Date 30 May 2022

RE: 6/2021/2857/MAJ - Tewin Road, Welwyn Garden City, AL7 1BD

Thank you for your consultation on the proposed change of use from former gasholder site and car dealership (Sui Generis) to industrial processes (E(g)(iii), general industrial (B2) and storage or distribution (B8) to include details of access, servicing, landscaping and boundary treatment.

Appendix 7: Proposed Drainage Layout

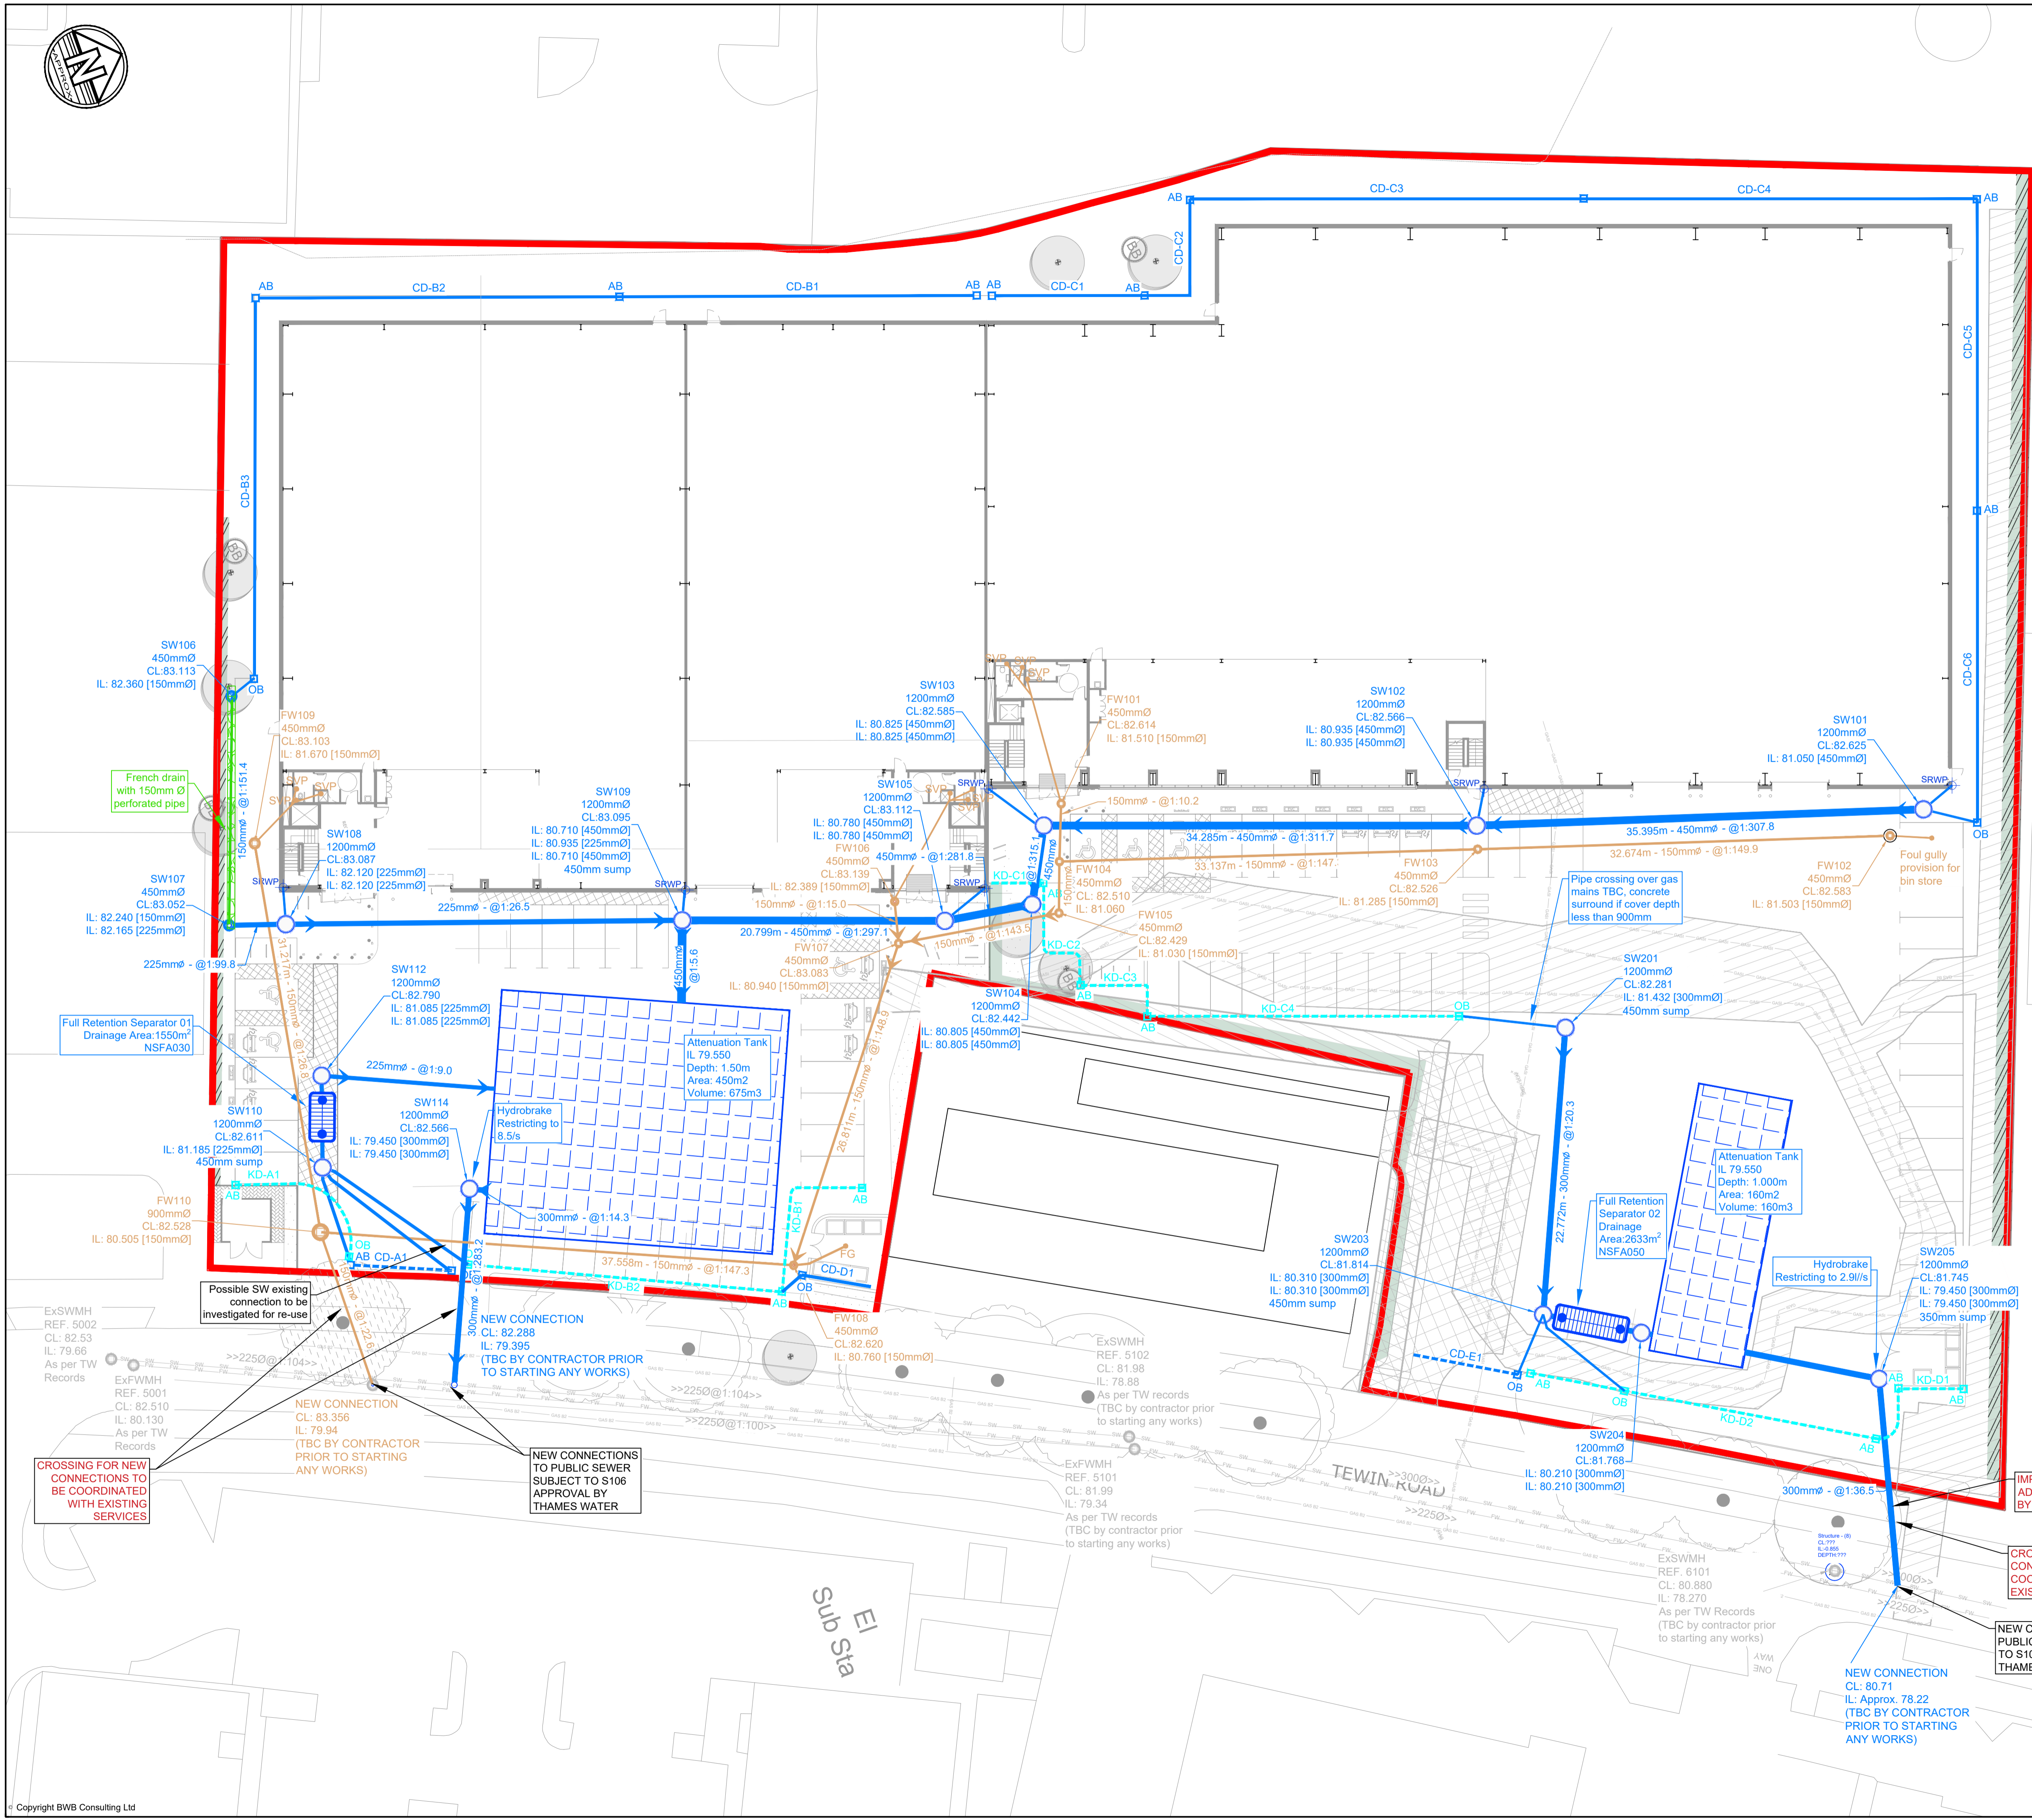
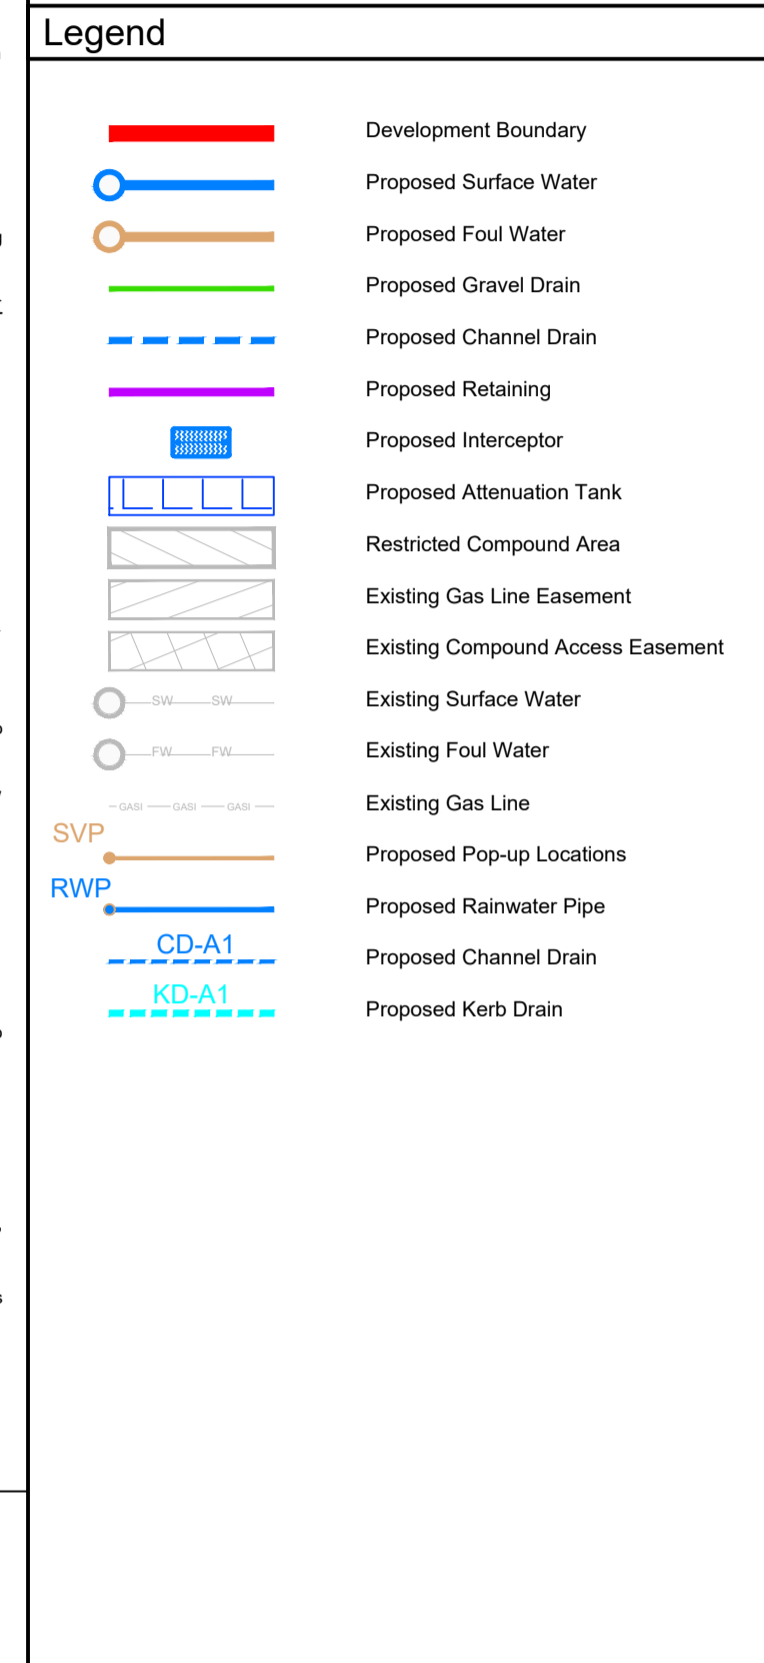
Furthermore, we note that a flooded volume of 13.93m³, 0.235 m³, 21.311m³, 6.434m³ and 4.774m³ is indicated to occur during the 1 in 100 year + 40% climate change storm at pipe numbers S1.001, S1.003, S1.005, S2.000 and S2.001 respectively. While we would not object to this in principle, we require the applicant to provide the location, depth, volume and area of this flooding on a drainage plan. We would recommend that this flooded volume is reduced as far as is practicable.

In addition, in Table 6.1 of the Drainage Strategy it is proposed to incorporate channel drain sumps and catchpit manholes in the proposed SuDS features however, the location of some proposed SuDS measures, pipe runs, discharge points and informal flooding is not included on this final drainage layout. This should be updated and appropriately indicated on a drawing.

4. The proposed surface water drainage scheme should be designed to cater for all rainfall events up to and including the 1 in 100 year + climate change event. There should be no flooding up to the 1 in 30 year rainfall event. Where this occurs this will be considered as 'informal' flooding and this should be managed within the site, demonstrating it will not increase flood risk to the site and the surrounding area. The extent and depths of these areas should be shown on a plan in relation to the proposed site levels.

Any flooding of the drainage system above the 1 in 100 year + climate change event is considered as an exceedance event and it should be shown on a development and drainage layout plan where these areas are and where surface water will flow, demonstrating there will be no increase in flood risk to the surrounding area. Capacity within upstream pipes, channels and filter drains should be accounted for at this stage.
